Subject: 2024/44/92806/W - Land at Penistone Road, Fenay Bridge

Please find attached further submissions to address comments raised by the LLFA, dated 7 February 2025.

Condition 20 (surface water discharge)

TITLE
DETAILS OF ATTENUATION/STORAGE
TANK DETAILS USING POLYSTORM
PSM1A UNIT.

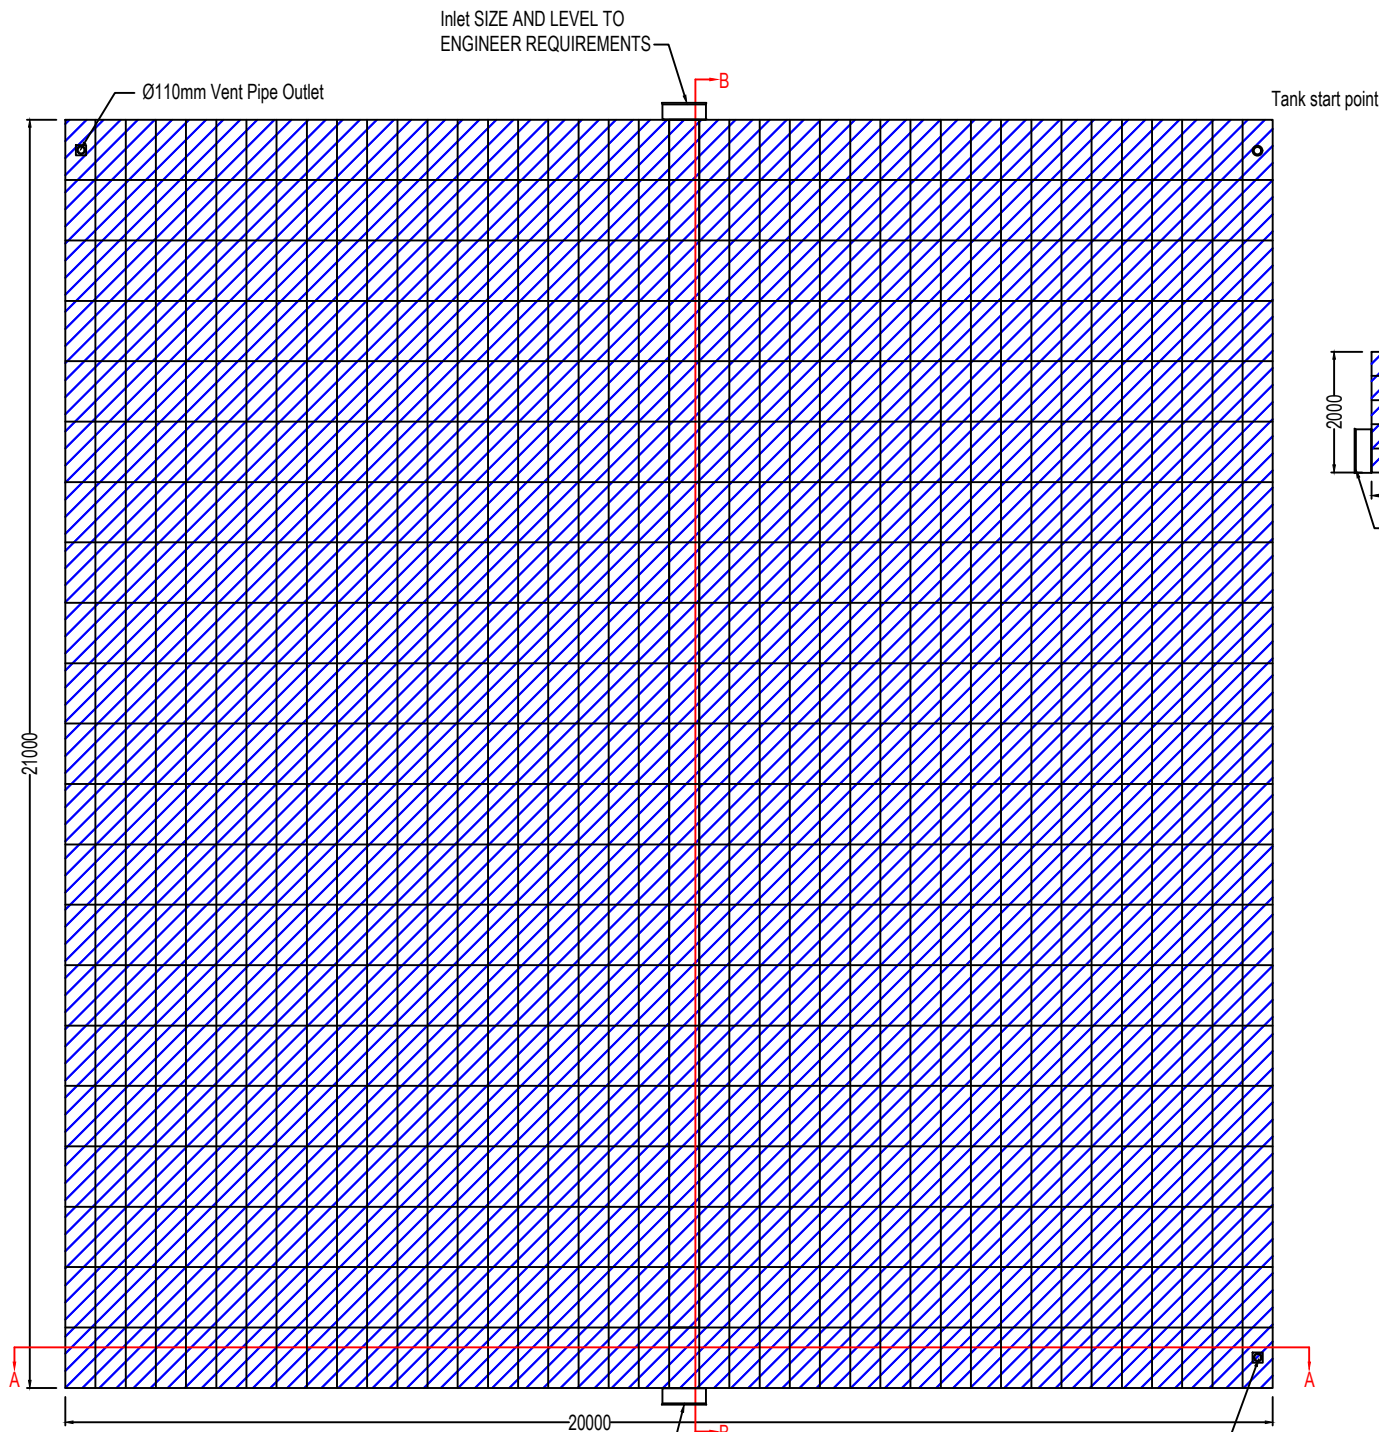
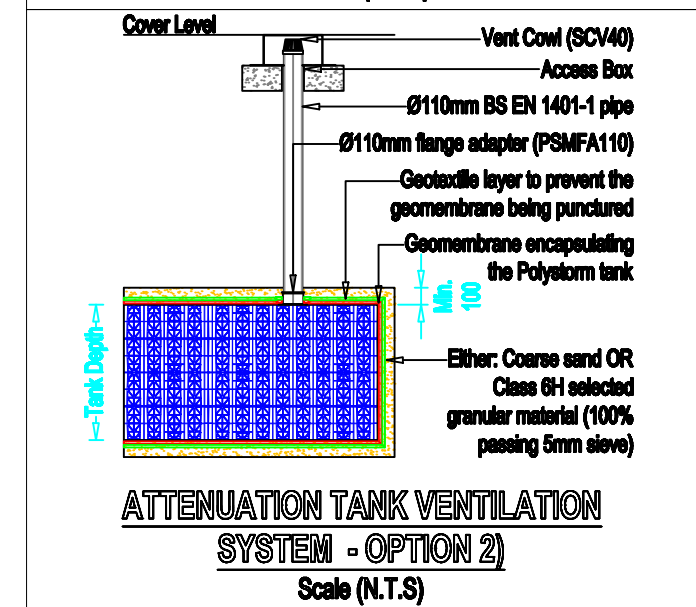
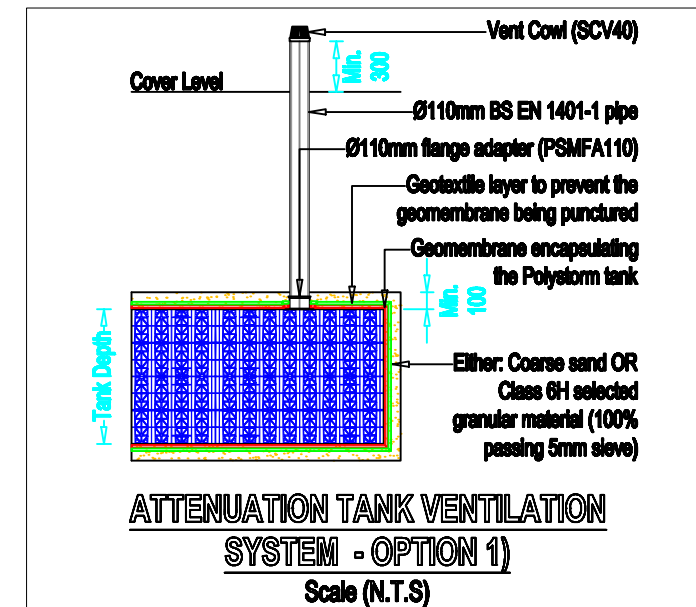
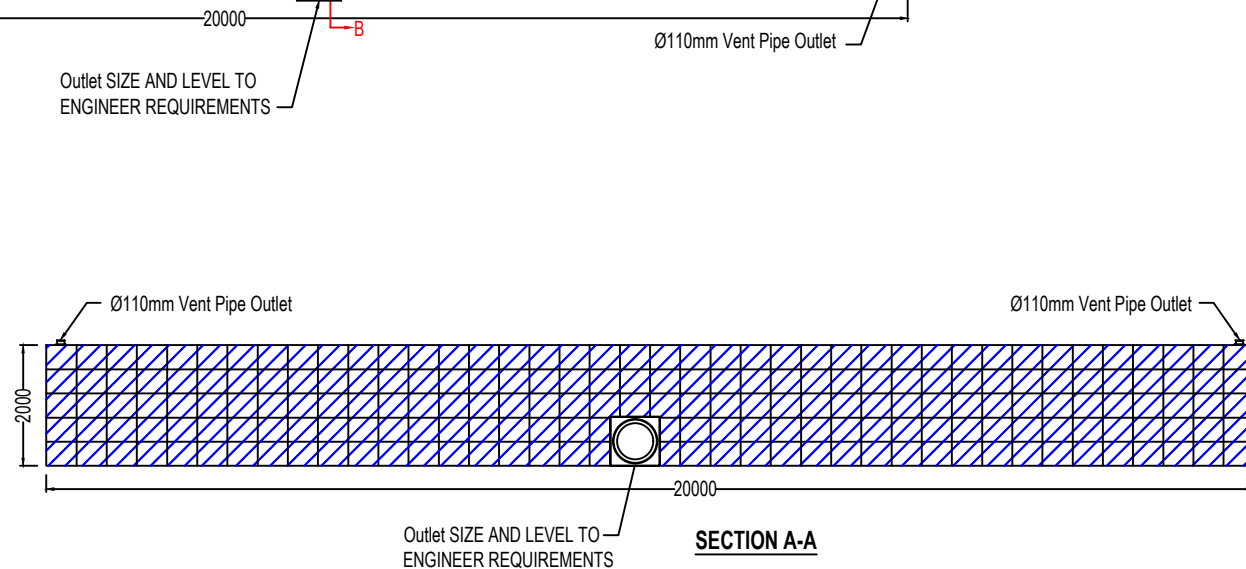
2. The submitted Polystorm data sheet, provides clarification on loading restrictions as requested.
3. Paragraph 3 is noted, matters of which are progressing outside of this application.
4. A copy of the Technical Approval from ICOSA, dated 26/11/2024, and conditions satisfied and removed, dated 09/01/2025.
5. The Operations & Maintenance Manual has been submitted to provide clarification on maintenance regime.
6. The submitted updated Drainage Layout, dwg no. 22-491-500-001H provides an additional spill inspection chamber.
7. Updated calculations provided: SWSv4 - 2025 - Surcharged Outfall and Cellular Storage.
8. The Operations & Maintenance Manual has been submitted to provide clarification on maintenance regime; and a Management Company Plan, dwg no. Z078-011-MCP provided to confirm management.

Drawing No. Z078 - 011-MCP	Rev -
-------------------------------	----------

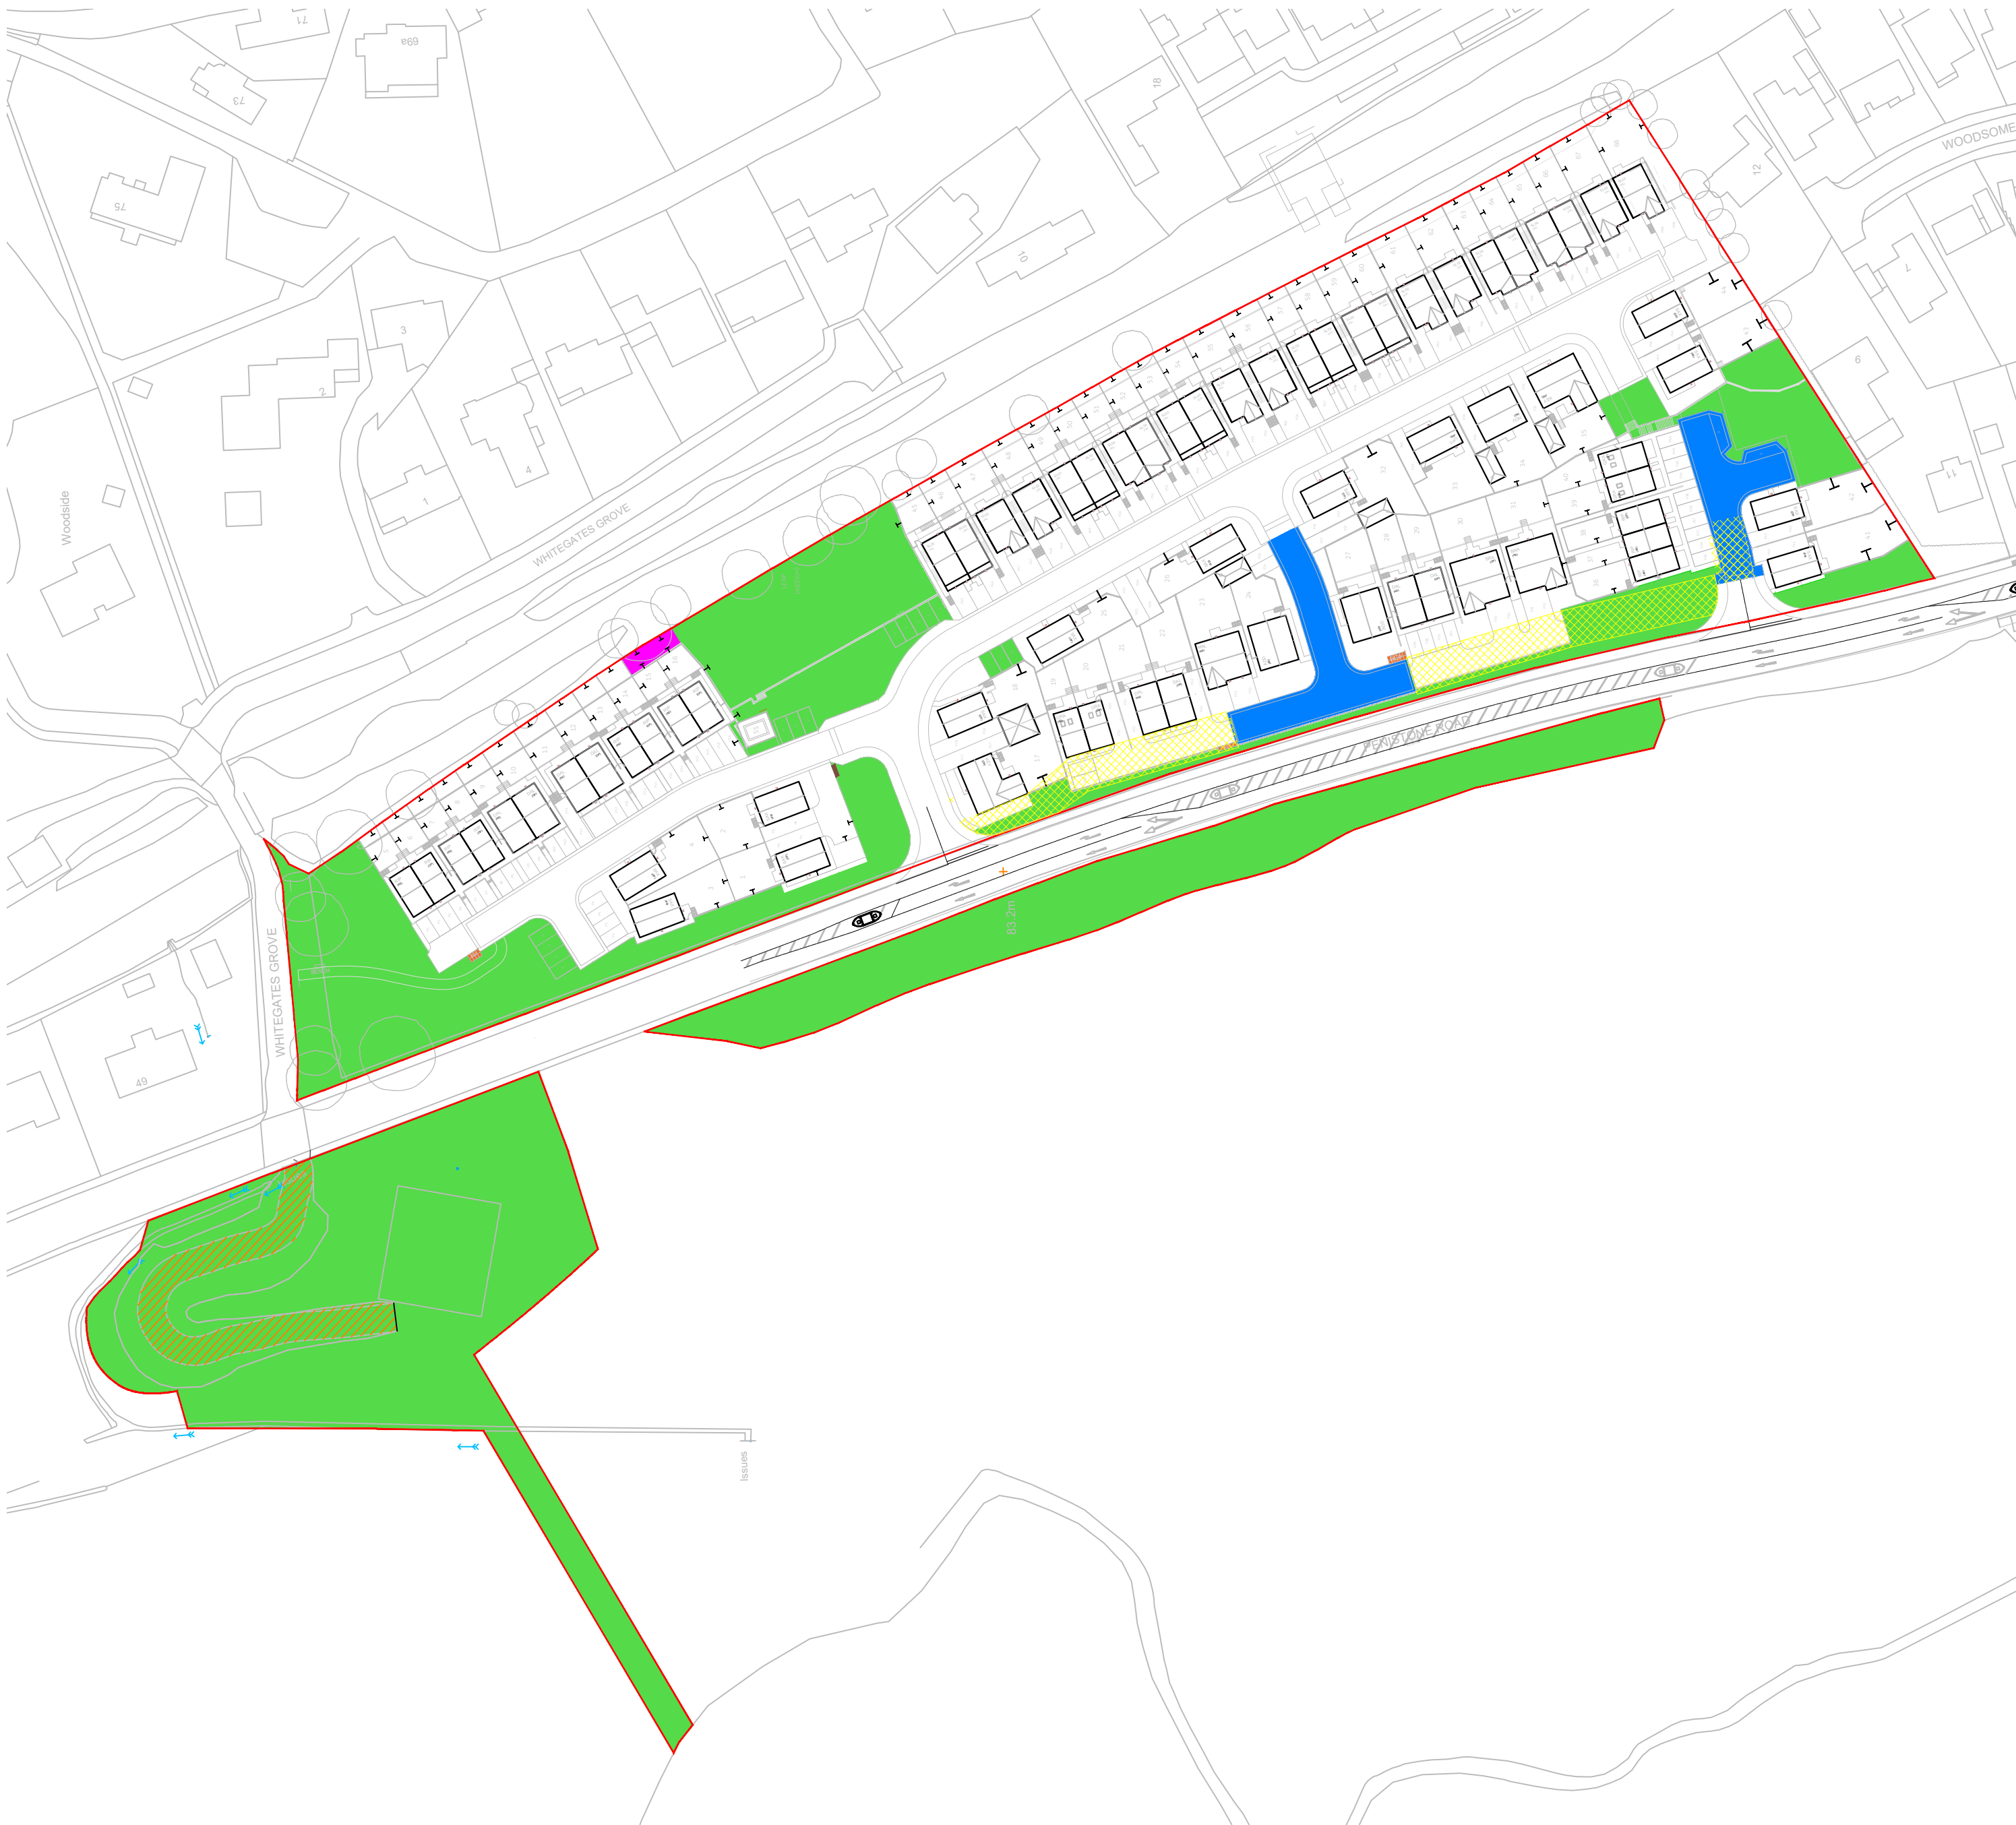
In respect of condition 31, the batter is to be installed no greater than 1:3 so within general design guide tolerance and not a gradient that would be classed as overly steep or requiring additional maintenance. The batter is covered under the management company (this is clearly shown on the Management Company Plan, dwg no. Z078-011-MCP).
